CITY OF PORTLAND, MAINE

PLANNING BOARD

March 10, 2016

Project Name:	Romasco Lane Subdivision: 4-Unit Condos	Project ID:	2016-023
Address:	5-9 Romasco Lane	CBL:	013 J024001
Applicant:	Legacy 18 Development Corporation		
Planner:	Shukria Wiar

**SITE AND UTILITY PLAN**

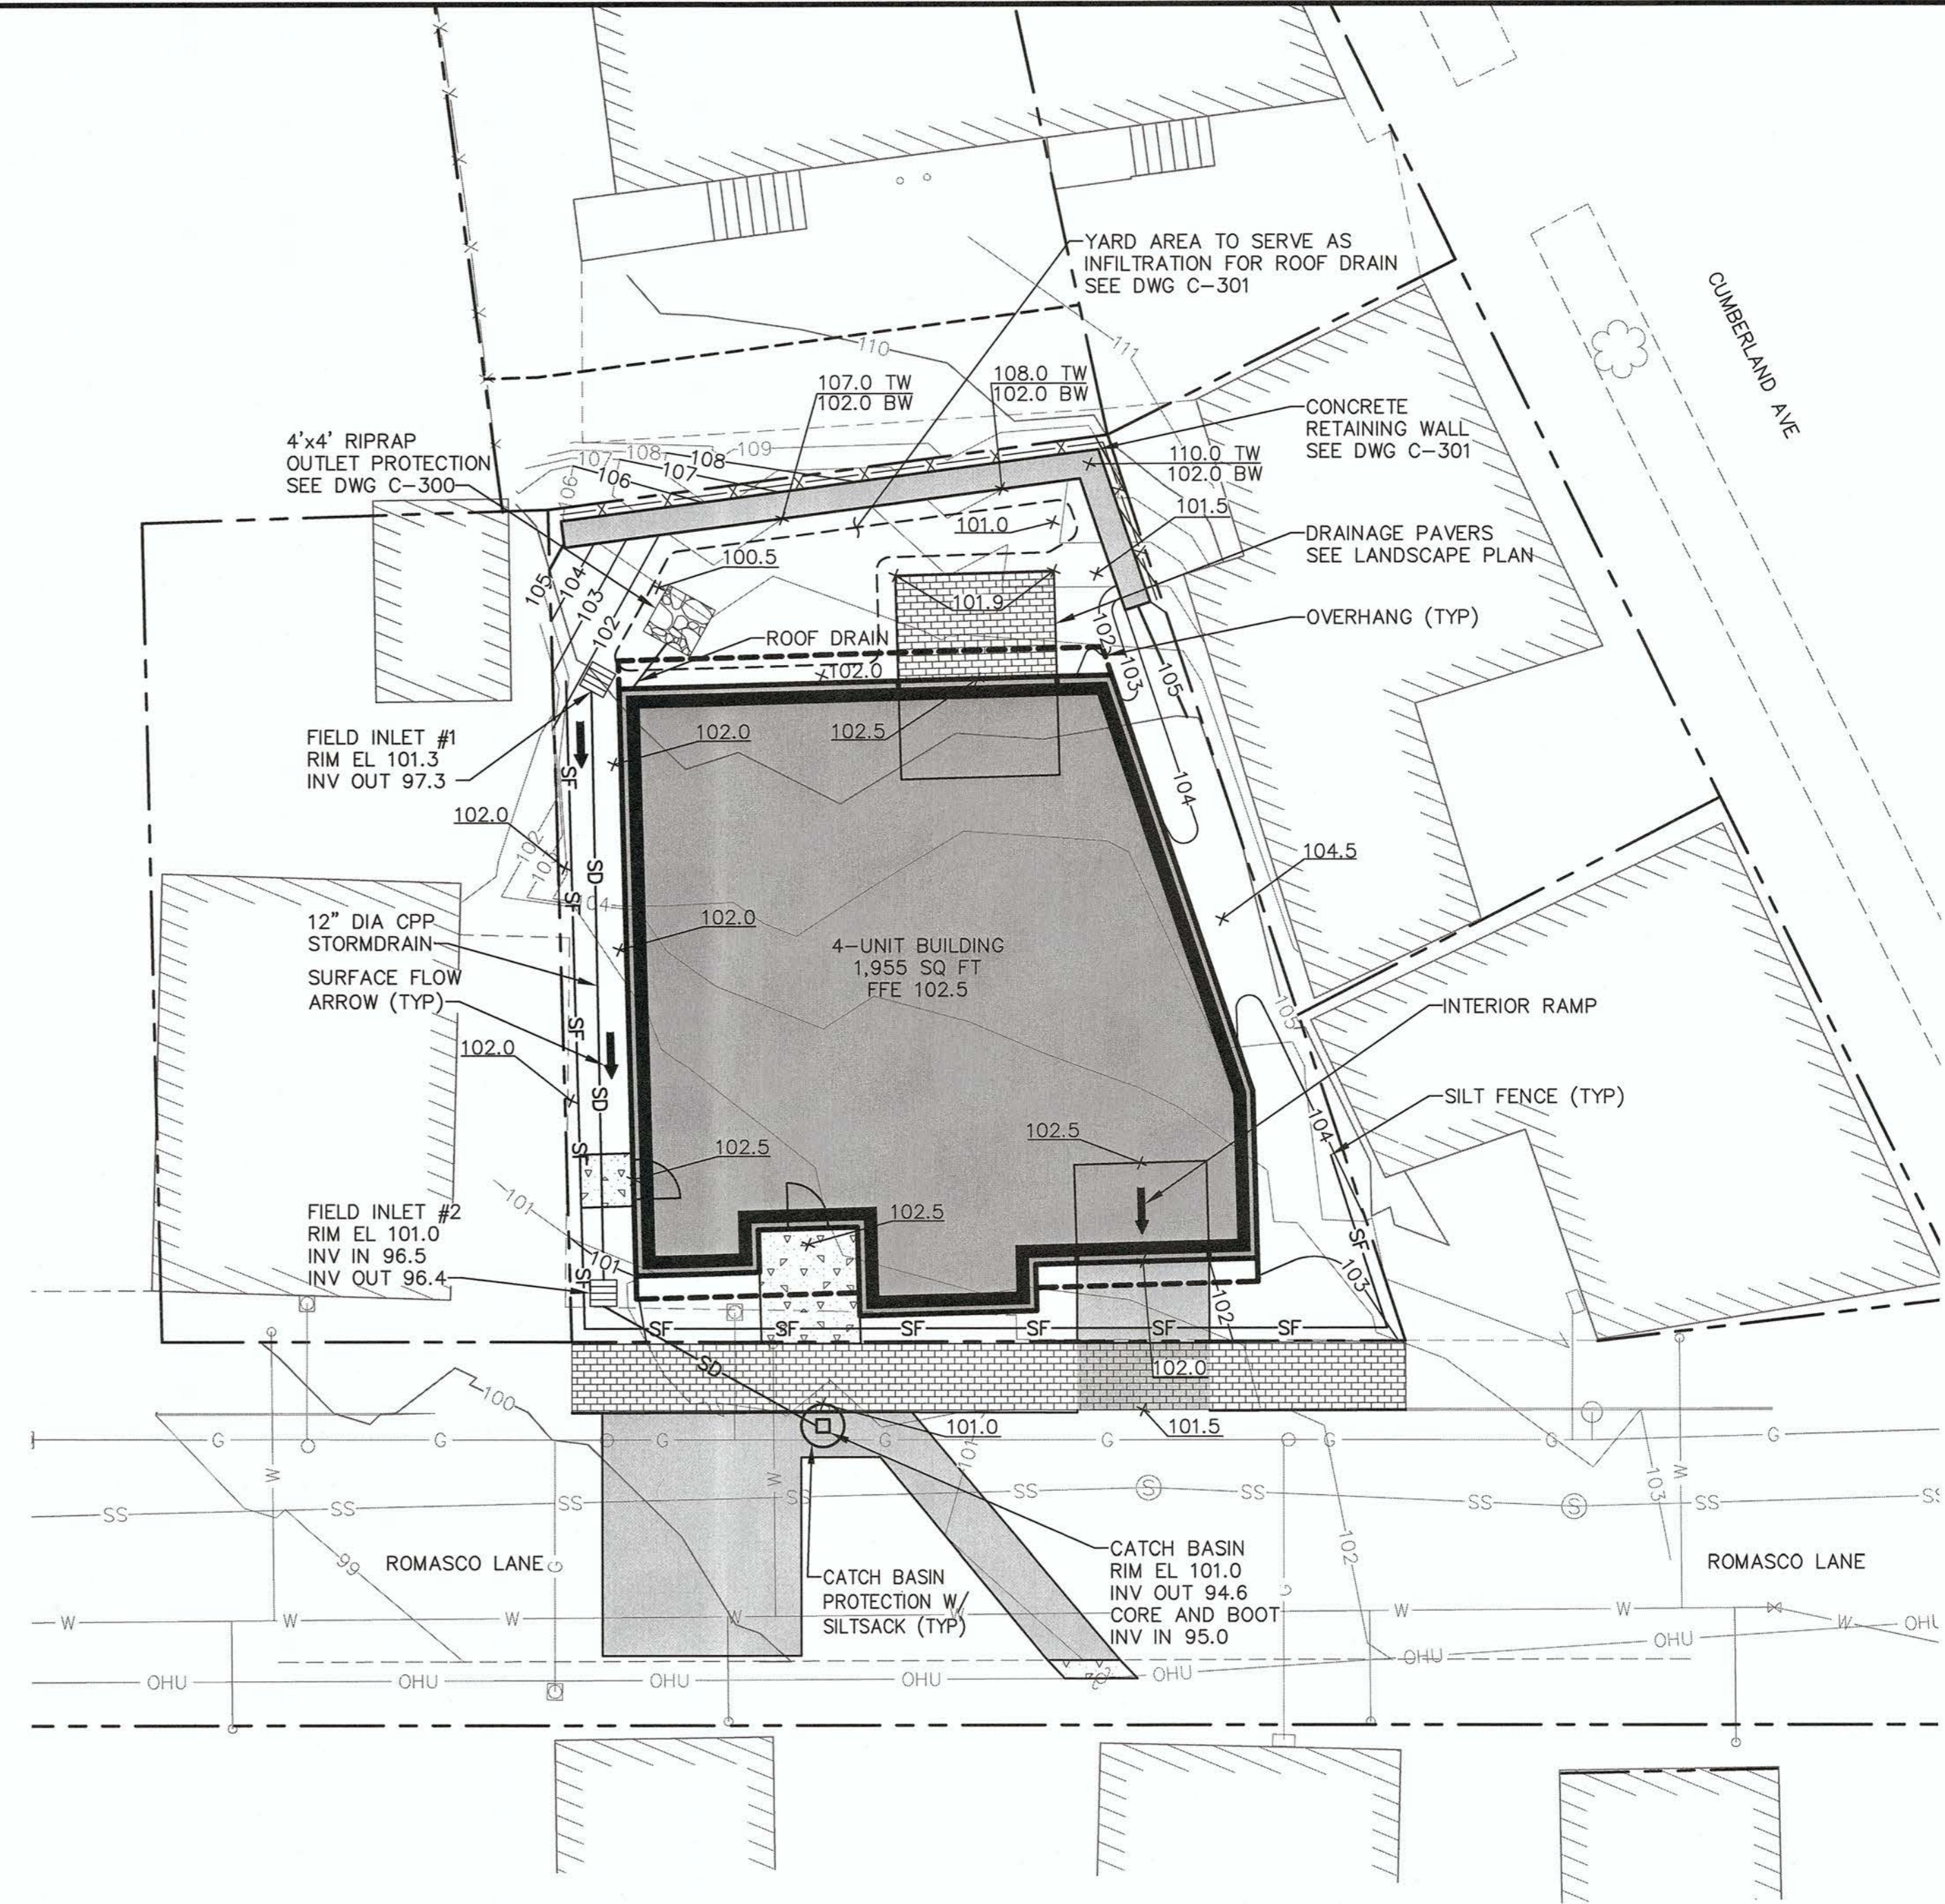
There are three parking spaces and these are located inside the garage of the building and away from the street view. The parking stalls are slightly wider than the nine feet wide standard. To meet the required zoning setback, the building will be angled on the southeast side. Due to this, the aisle width in the garage varies from 18 to 24 feet and the City standard is 24 feet. Tom Errico has reviewed this and supports waivers on both standards, see below:

The average parking stall width will be slightly wider than the City standard of 9 feet. I find this condition to be acceptable and support a waiver from City standards.

The parking aisle width for circulation purposes will range from 18 to 24 feet (24 feet is the City standard). Given that the project will be providing a rear garage door to assist with vehicle circulation, and that Romasco Lane has very low traffic volumes and speeds (I find backing maneuvers from the site to be reasonable), I find conditions to be acceptable and support a waiver from City standards.

1. The Planning Board finds that the applicant has demonstrated that extraordinary conditions unique to this property exist that limit the ability to meet the aisle width standard of 24 feet and the parking stall width standard of nine feet and Mr. Errico has found that the proposed widths provide safe on-site circulation; and the Board finds that the public interest and purposes of the land development plan are secured. The Planning Board therefore waives *Technical Manual 1.7.2.3. Minimum driveway width (two-way)* and *1.14. Parking Lot and Parking Space Design* to allow a varied aisle width of 18 to 24 feet and parking space width of nine and half in the garage.

PLAN SHOWING SUBDIVISION AND TOPOGRAPHY OF LAND AT
5-9 ROMASCO LANE, PORTLAND, MAINE
MADE FOR OWNER OF RECORD
JUDY GEORGE
MAILING ADDRESS:
233 SMITH ROAD, WINDHAM, MAINE, 04062
LIVINGSTON-HUGHES
PROFESSIONAL LAND SURVEYING CORPORATION
88 GUINEA ROAD, KENNEBUNKPORT, MAINE 04046

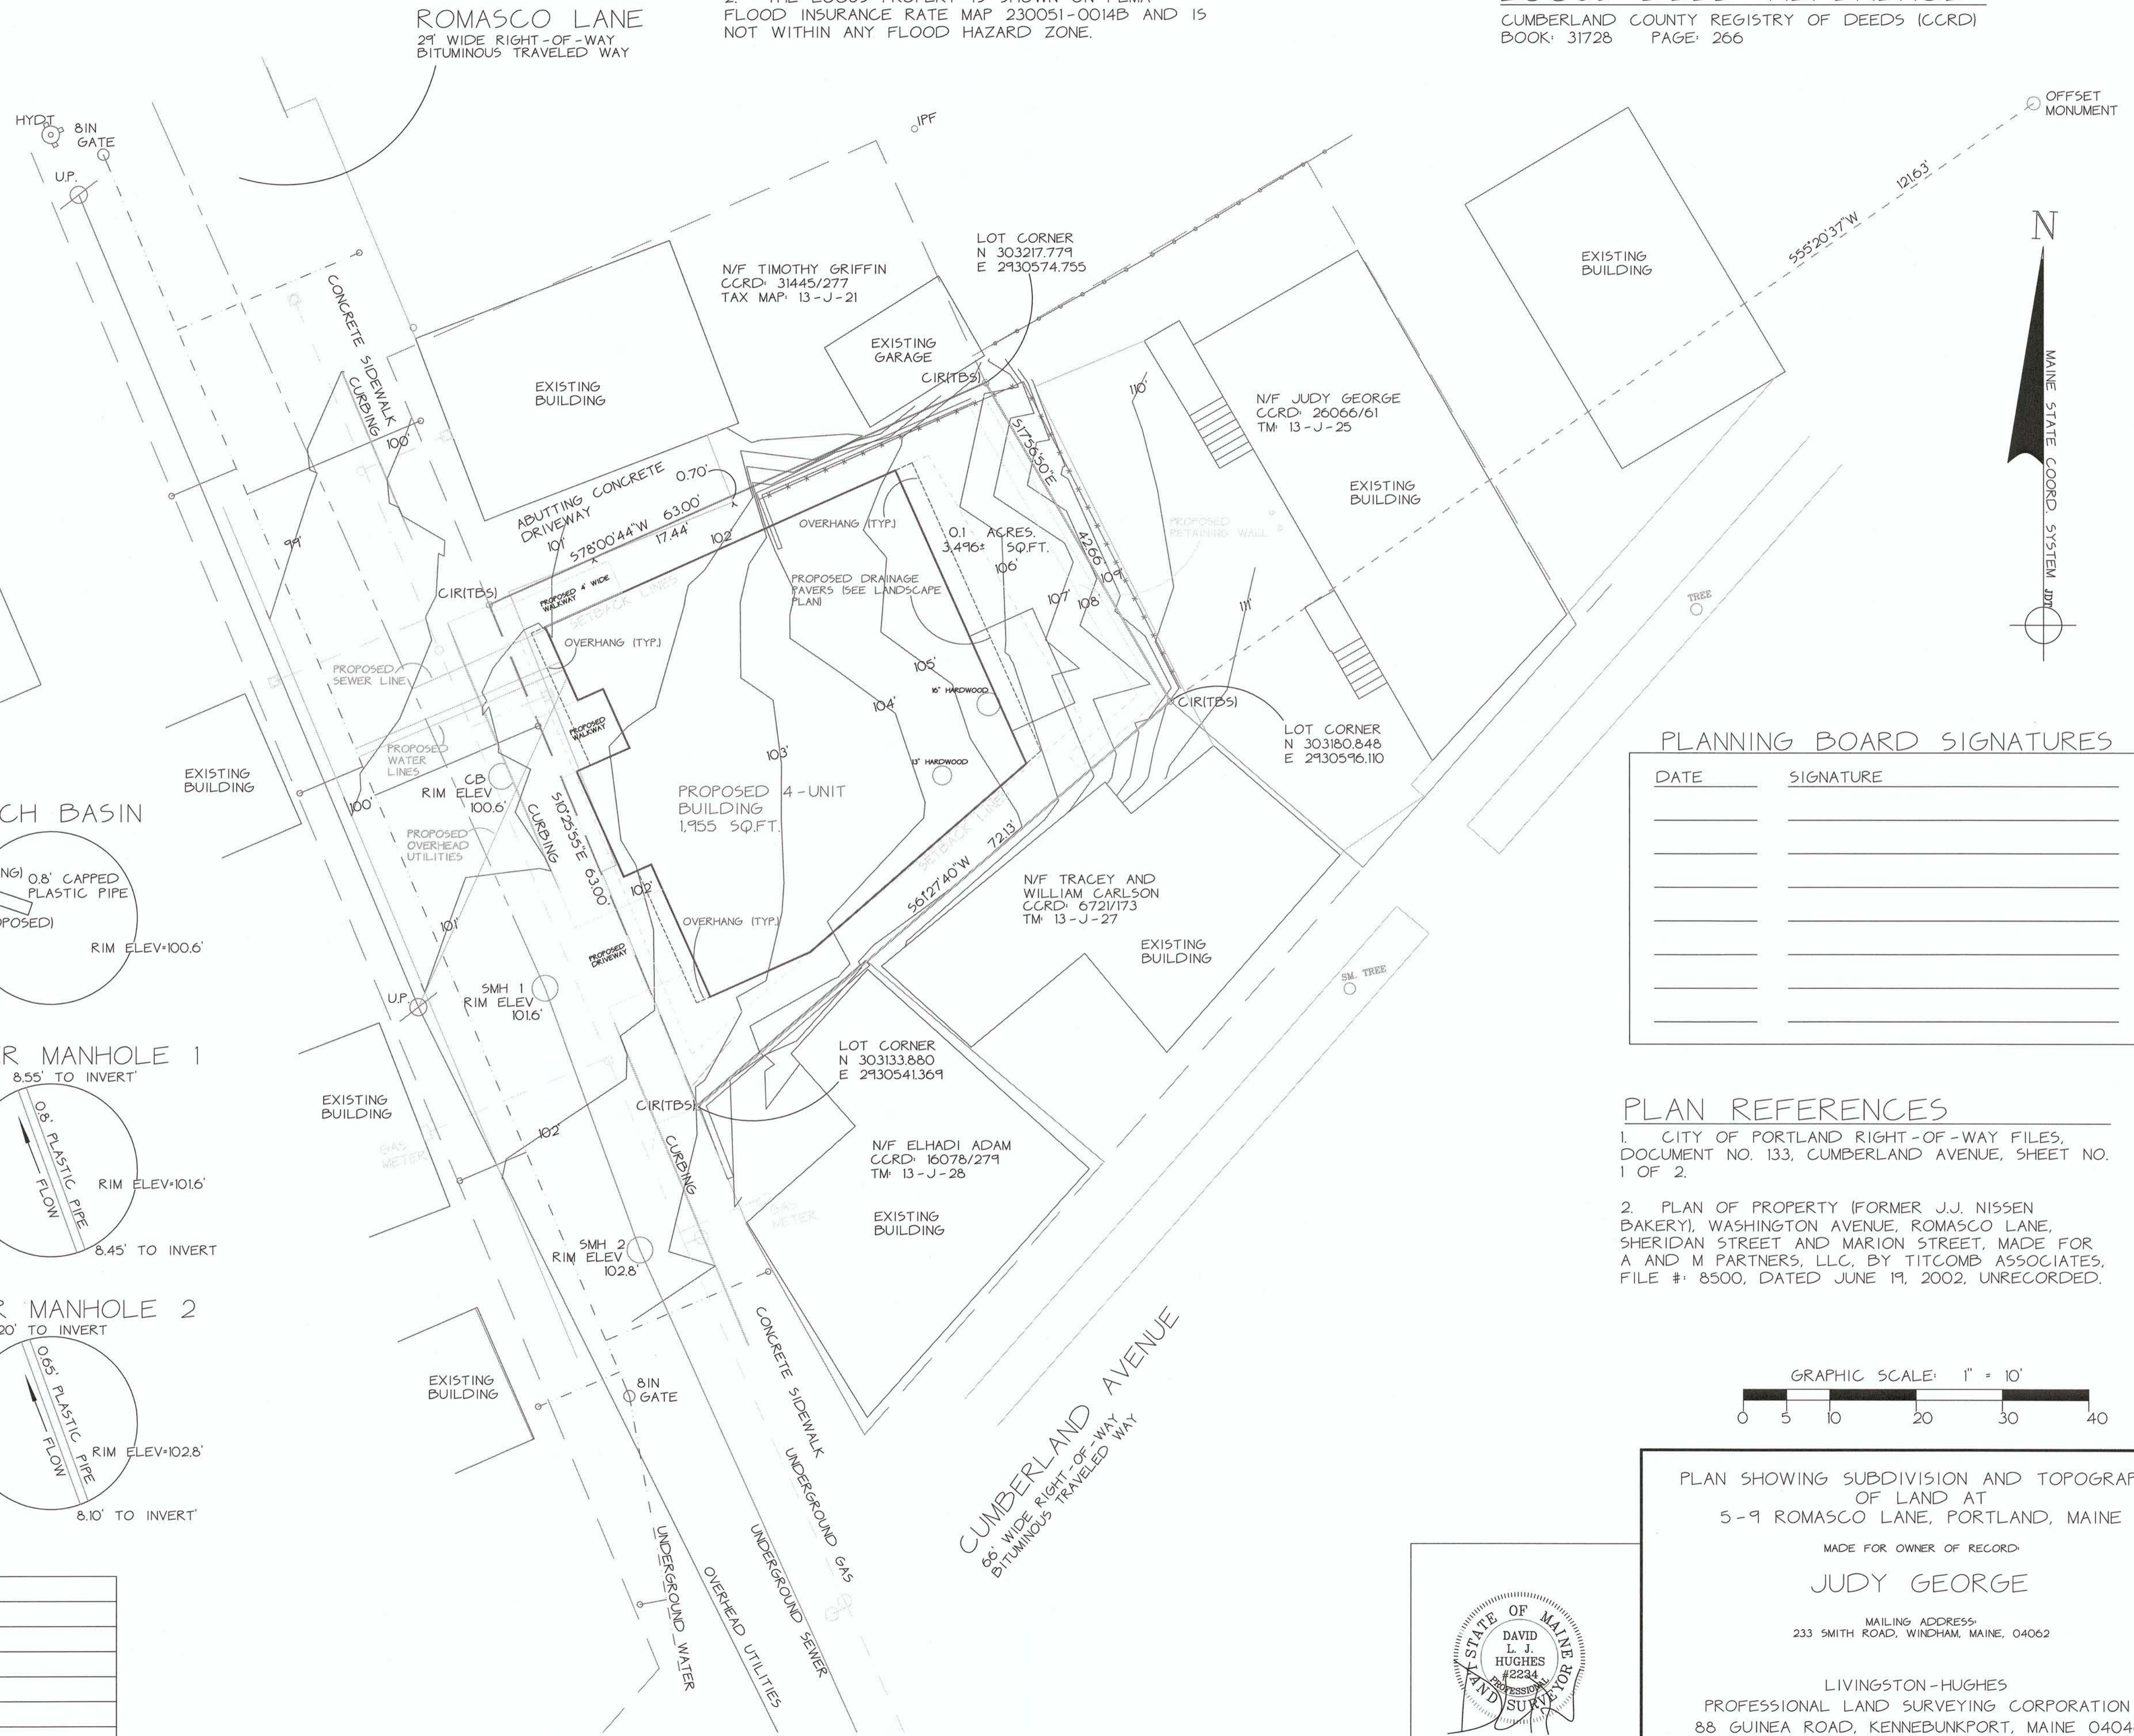
The site survey incorrectly shows the sewer utilities in the street. The applicant is working with the City Surveyor to accurately identify the sewer utilities. A potential condition of approval:

The final survey, site plan and subdivision plat shall correctly illustrate the sanitary sewer in Romasco Lane.
